ABTR Storage  
Traffic Impact Study  
(LSC #S234070)  
May 18, 2023

Add PCD File No.  
CS-232

## Transportation Memorandum

Figure 8

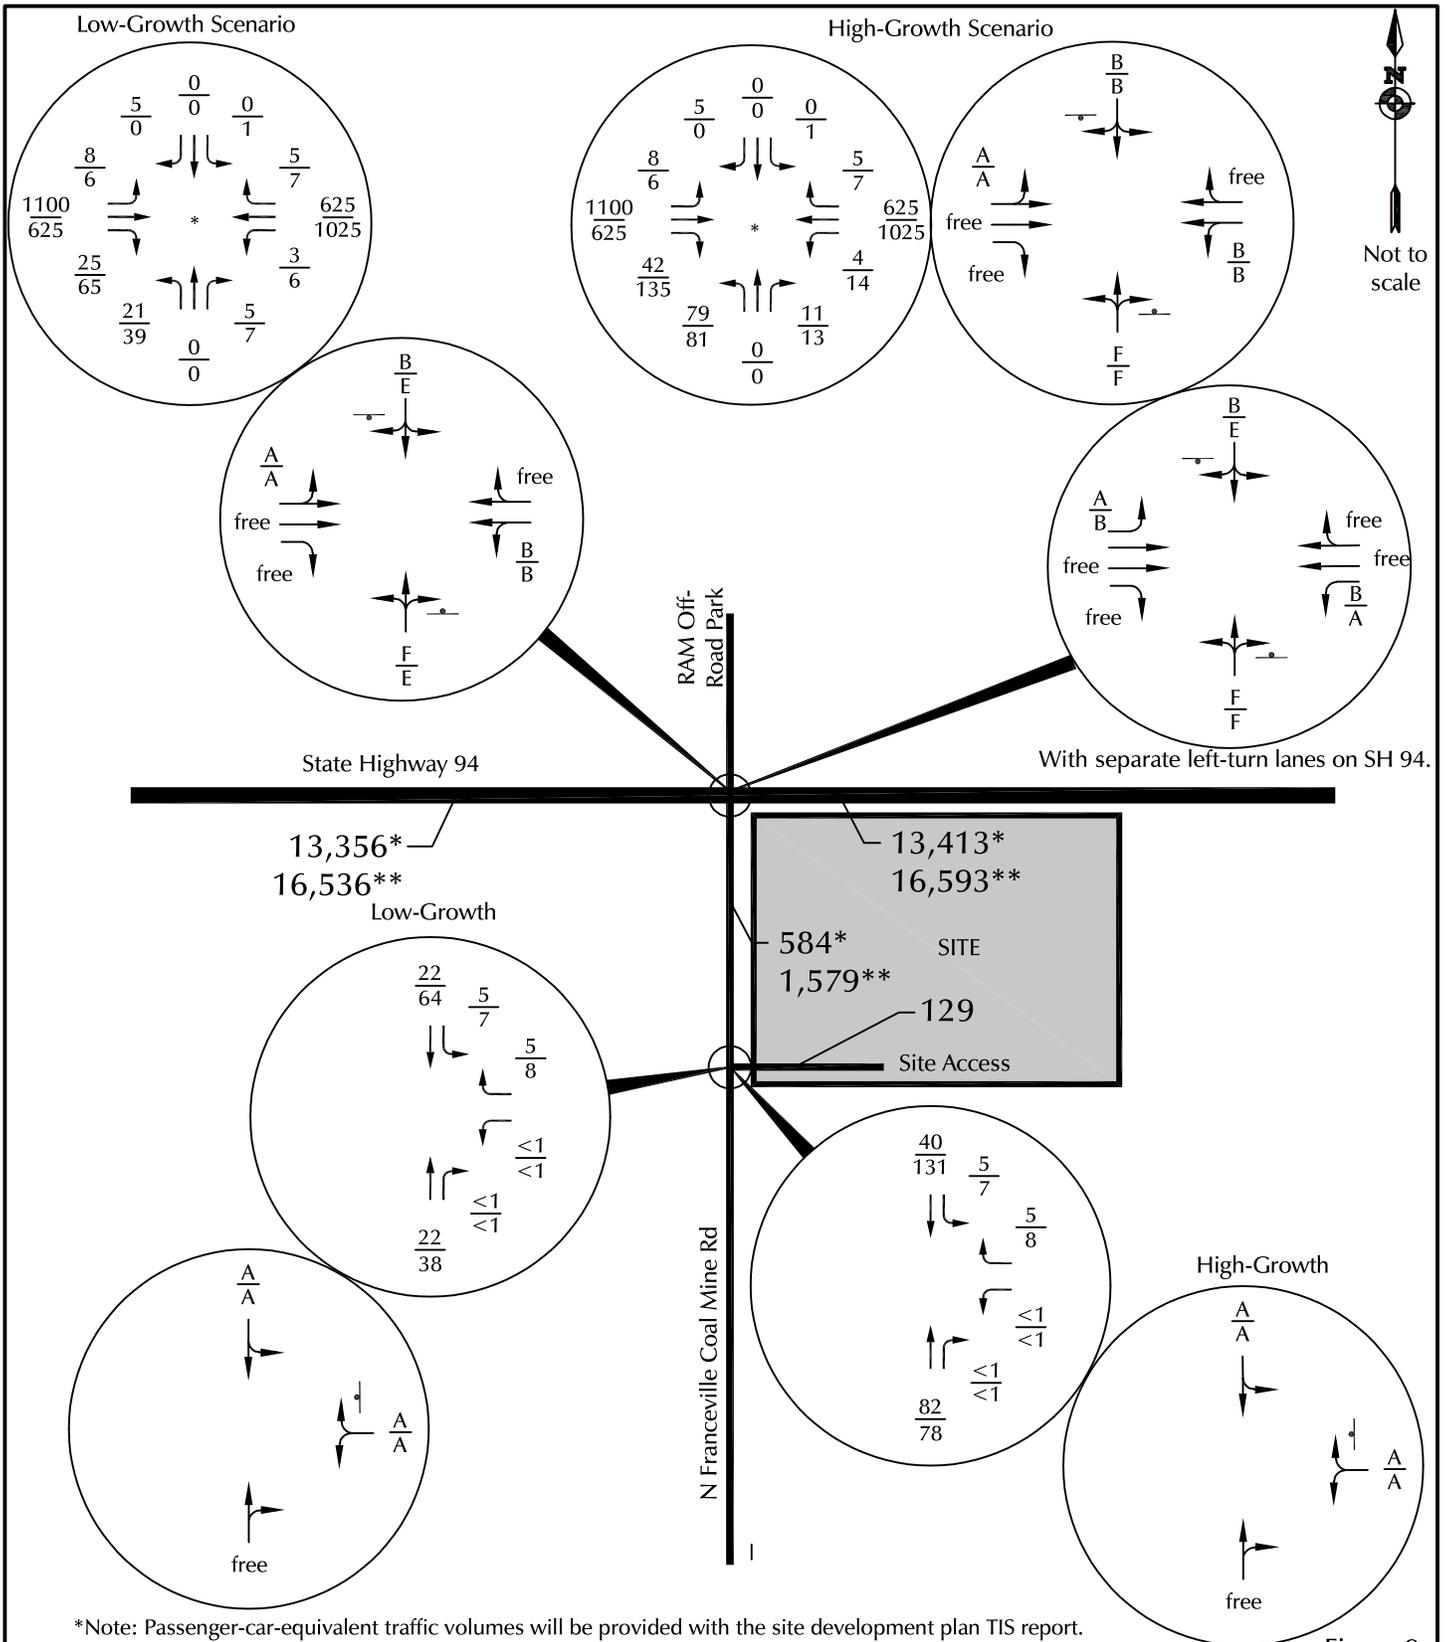
Adjust background to include the trips generated by Gateway Trucking in addition to the background traffic from the referenced report or revise the statement if the Gateway Trucking is already incorporated.
